LDG- **313306-22**

APPENDIX 1: Response to KCC Report
(Refer to parks report in Appendix B of KCC's planning report for full details)
Issue 3

The Big Space Ltd

BOUNDARY DETAILS -(SCALE 1:50 @A1)

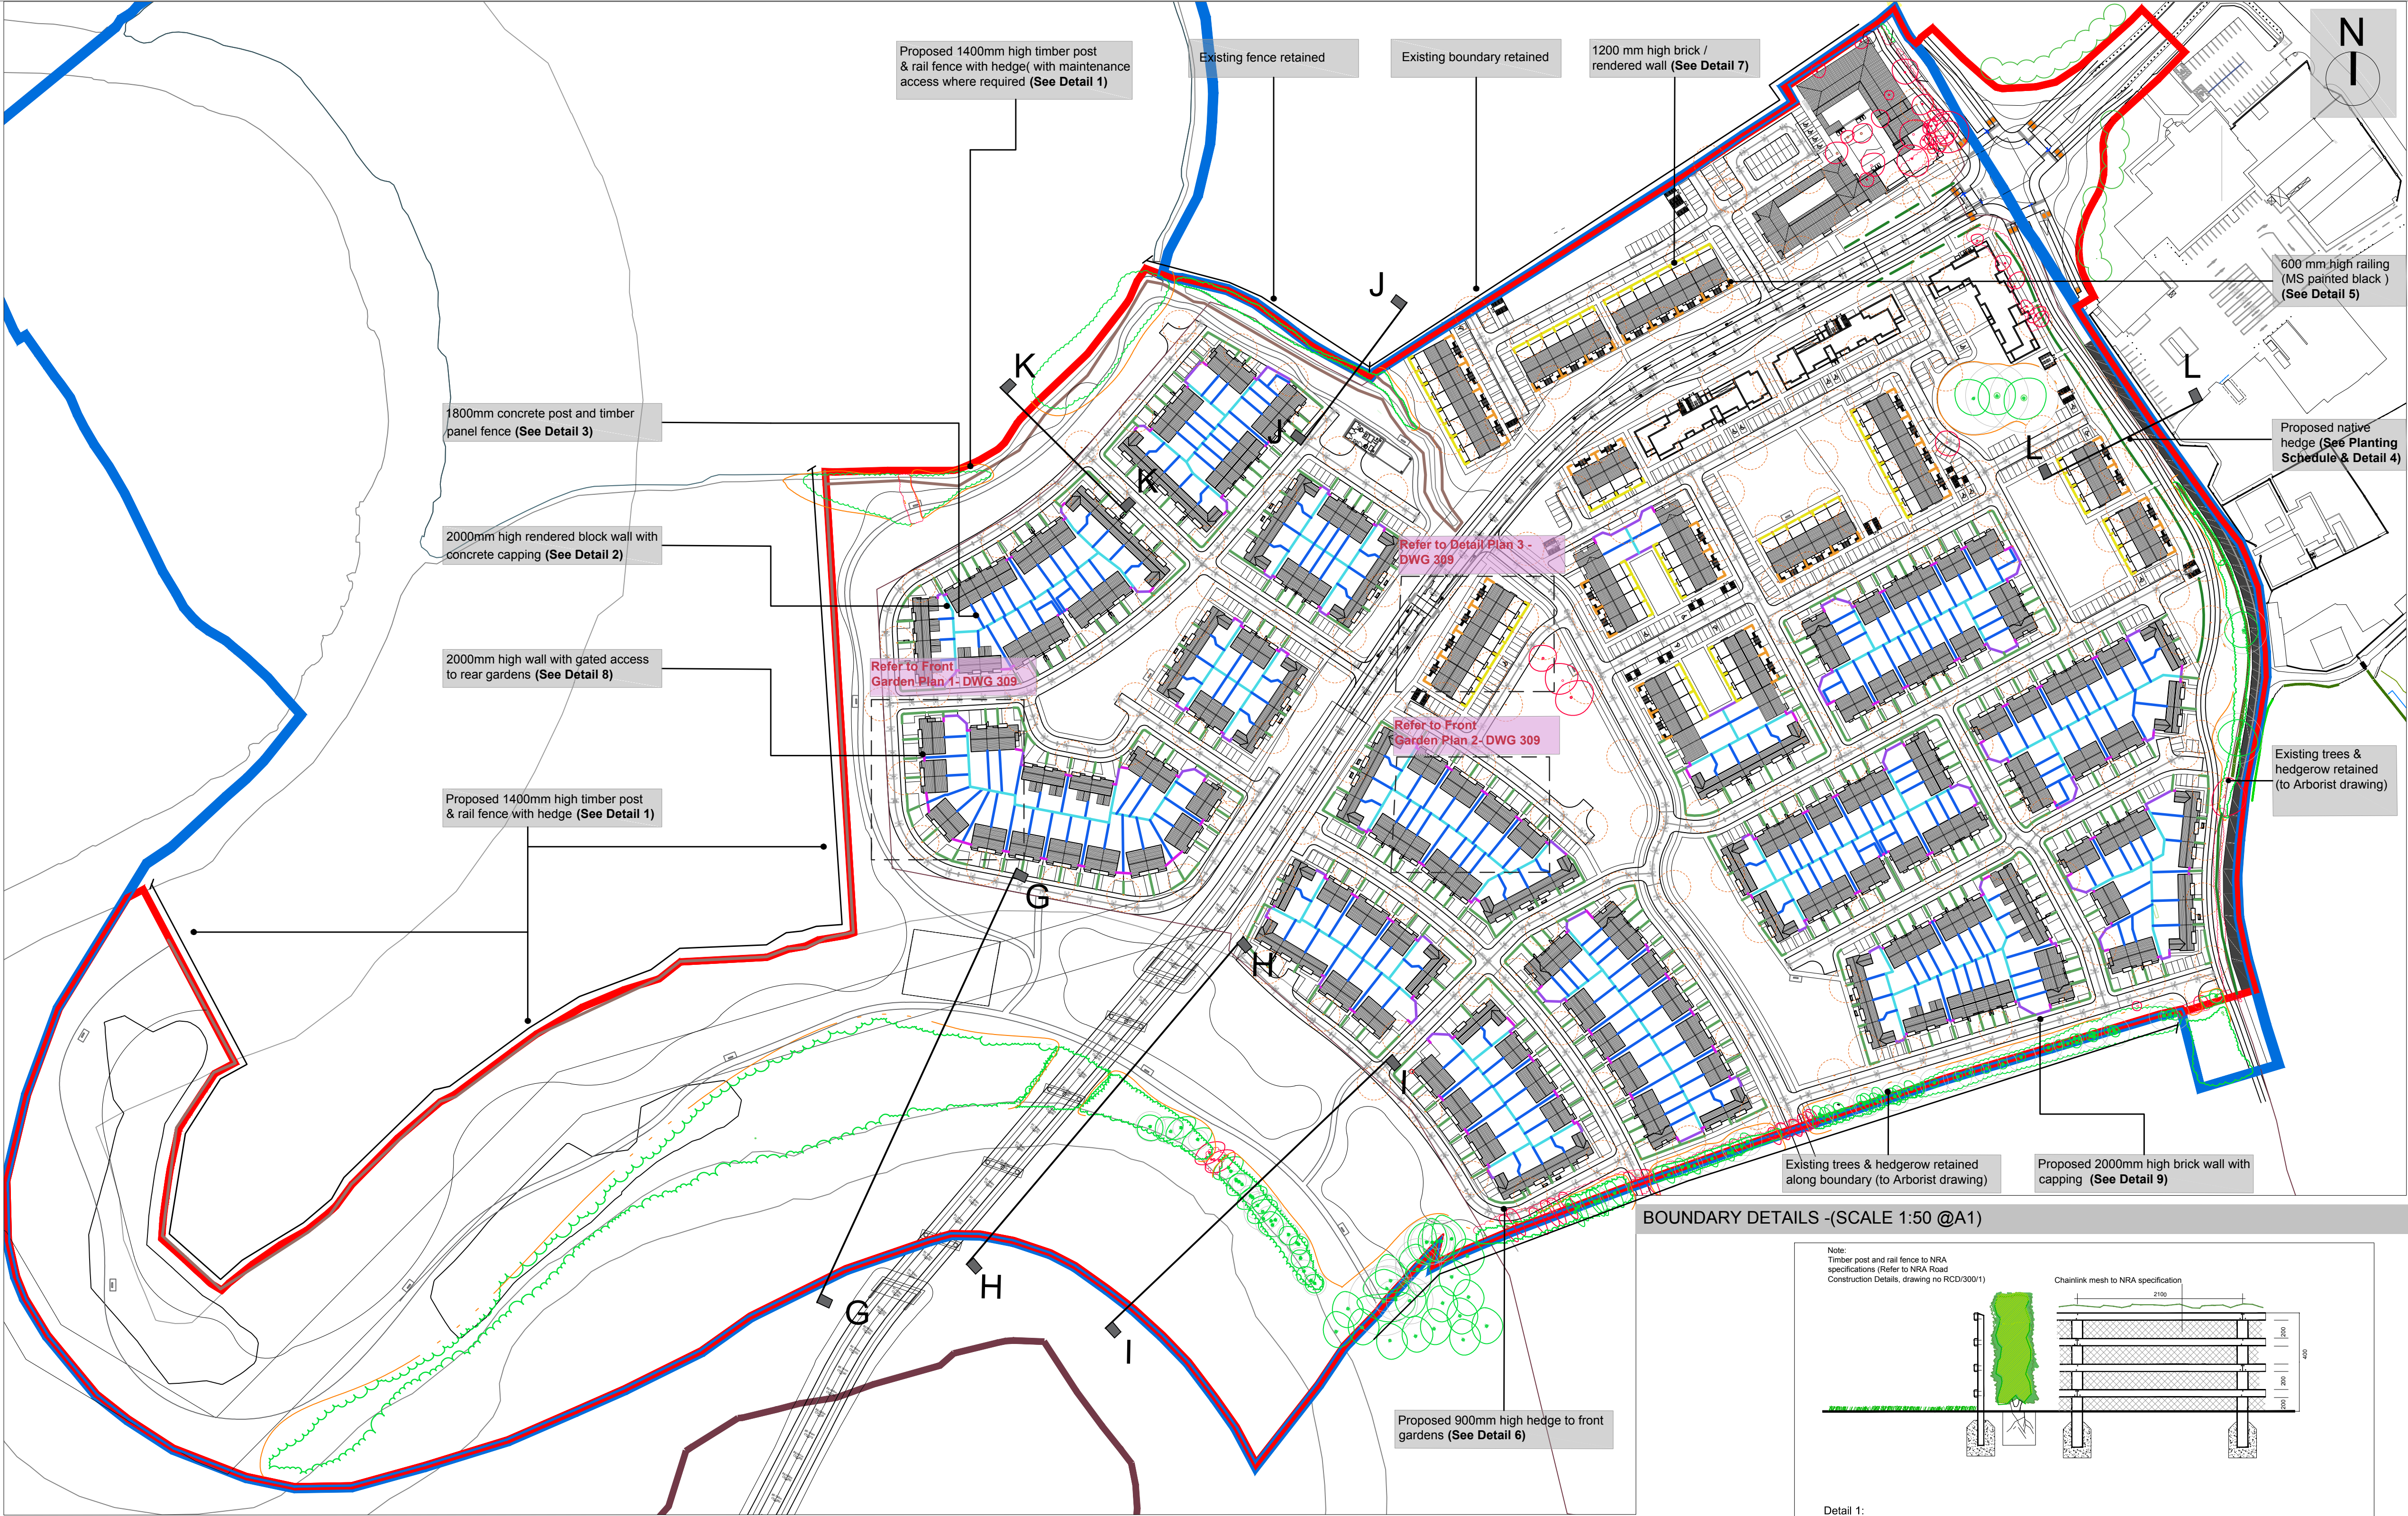
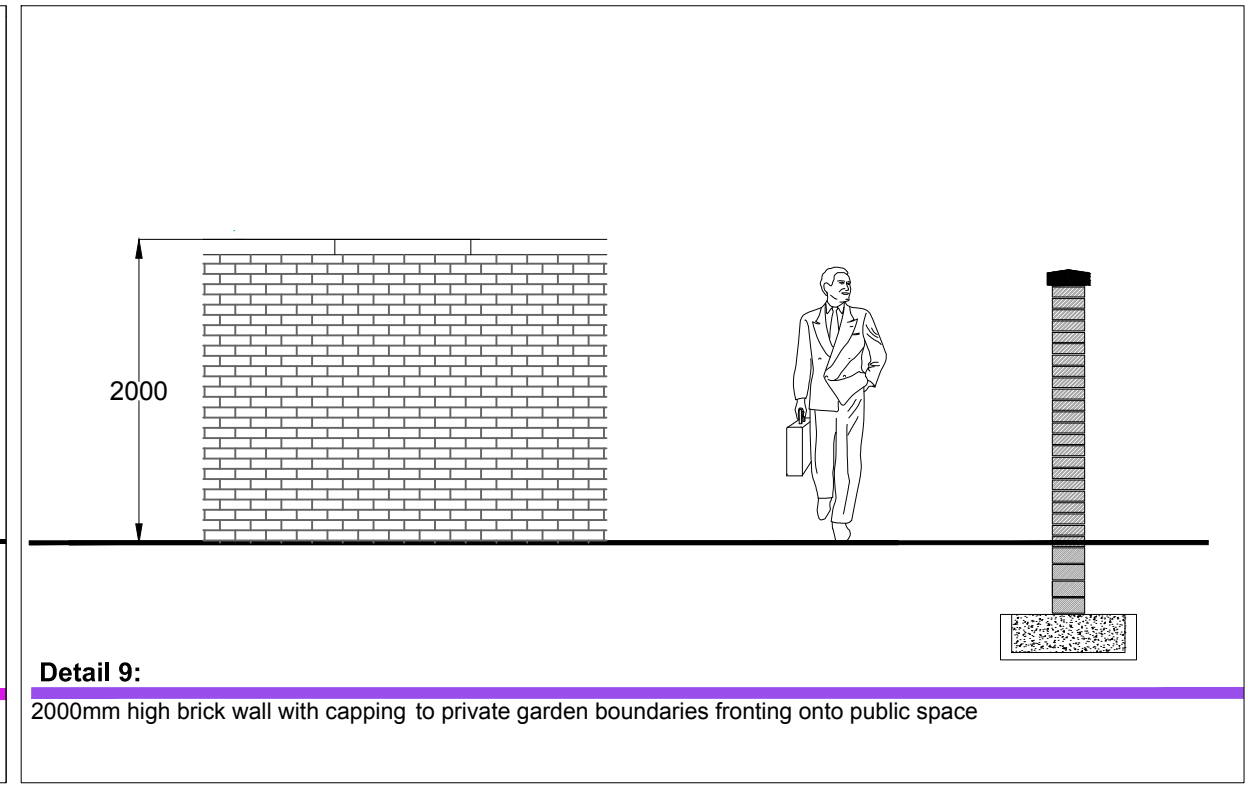
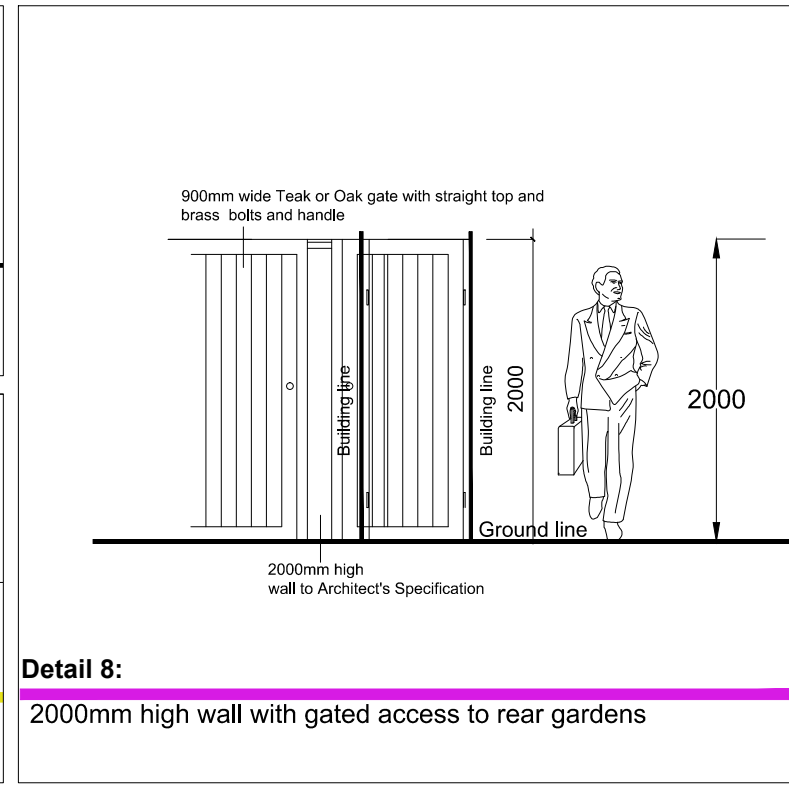
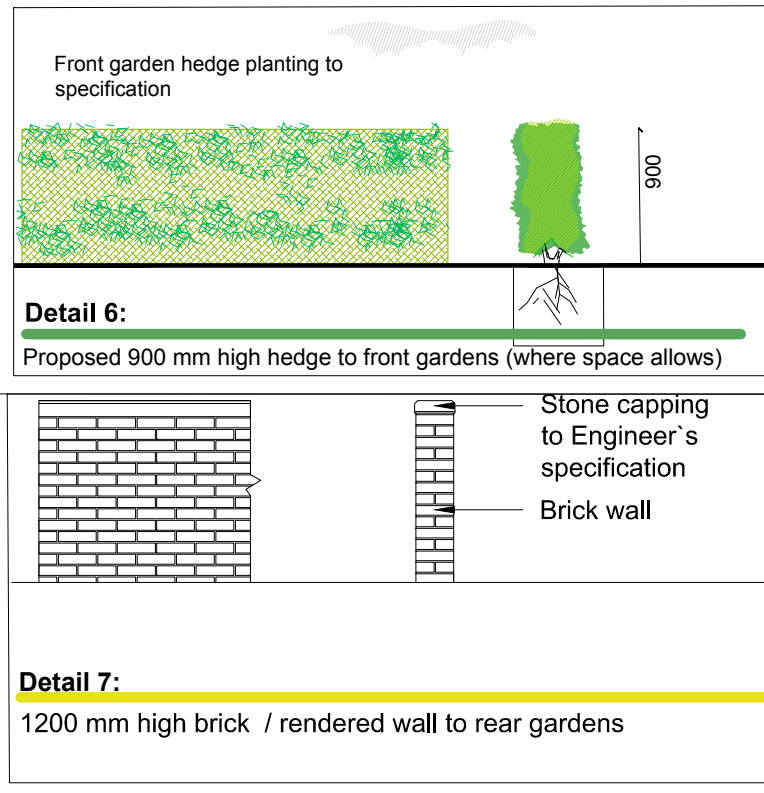
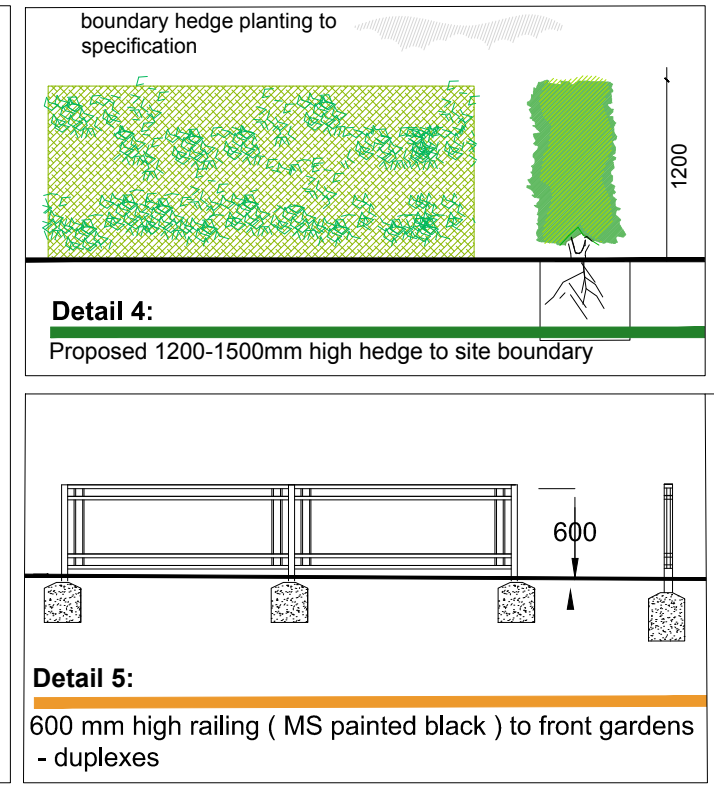
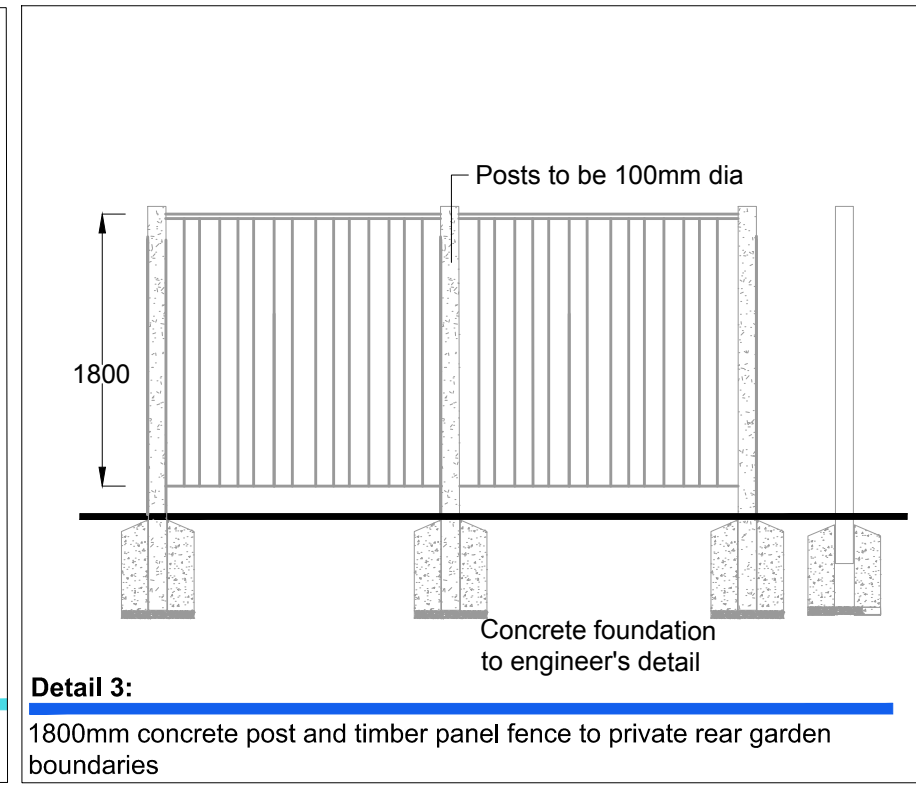
<p>area generally.</p> <p>Passive supervision of all public spaces is provided by the arrangement of dwellings overlooking the spaces. Refer to architects dwgs for same.</p>
<p>It is a requirement of the Parks Section that the housing layout plans and section drawings (north-south and east-west) that ensure the orientation of housing in the vicinity of open space is orientated to facilitate passive supervision.</p>	<p>Refer to architects revised site plan. Passive supervision of all public spaces is provided by the arrangement of dwellings overlooking the spaces.</p>
<p>Detail Design Item</p>	
<p>Existing hedgerows and trees are retained and protected as much as possible</p>	<p>Refer to arborists dwgs and report for information on same. TBS drawings 300-311 also indicate retained hedgerows.</p>
<p>Boundary treatment proposals to provide comprehensive details of how treatments will not render areas of inter alia land, hedgerow, trees, drainage ditches, or utility cabinets inaccessible or unable to be maintained or create areas of 'no man's land' between this and possible future developments</p>	<p>Refer to engineer's dwgs for locations of all drainage ditches, SuDS, proposed services, utility cabinets etc.</p> <p>Refer to TBS dwgs 306 & 307 for proposed boundary treatments. All areas are accessible for maintenance purposes</p>

<p>The boundary treatment and landscape proposals shall also show a comprehensive suite of section drawings through all boundaries to illustrate existing and proposed finished topography of adjacent areas</p>	<p>Refer to TBS dwgs 306 -307 for proposed boundary treatments inc:</p> <p>Section G-G, H-H, I-I, J-J',K-K' & L-L' in dwg 307</p>
<p>It is a requirement of the Parks Section that the layout plan for the proposed development ensures that the existing trees and hedgerow along the southern boundary are retained and protected during construction.</p>	<p>Refer to arborists dwgs and report for information on same. The revised site plan allows for the retention and protection of the existing hedgerow along the southern boundary. Also indicated on TBS dwg 300.</p>
<p>Comprehensive details including a programme of works shall also be provided for remedial and improvement works to the existing boundary trees and hedgerows.</p>	<p>Refer to arborists dwgs and report for information on same</p>
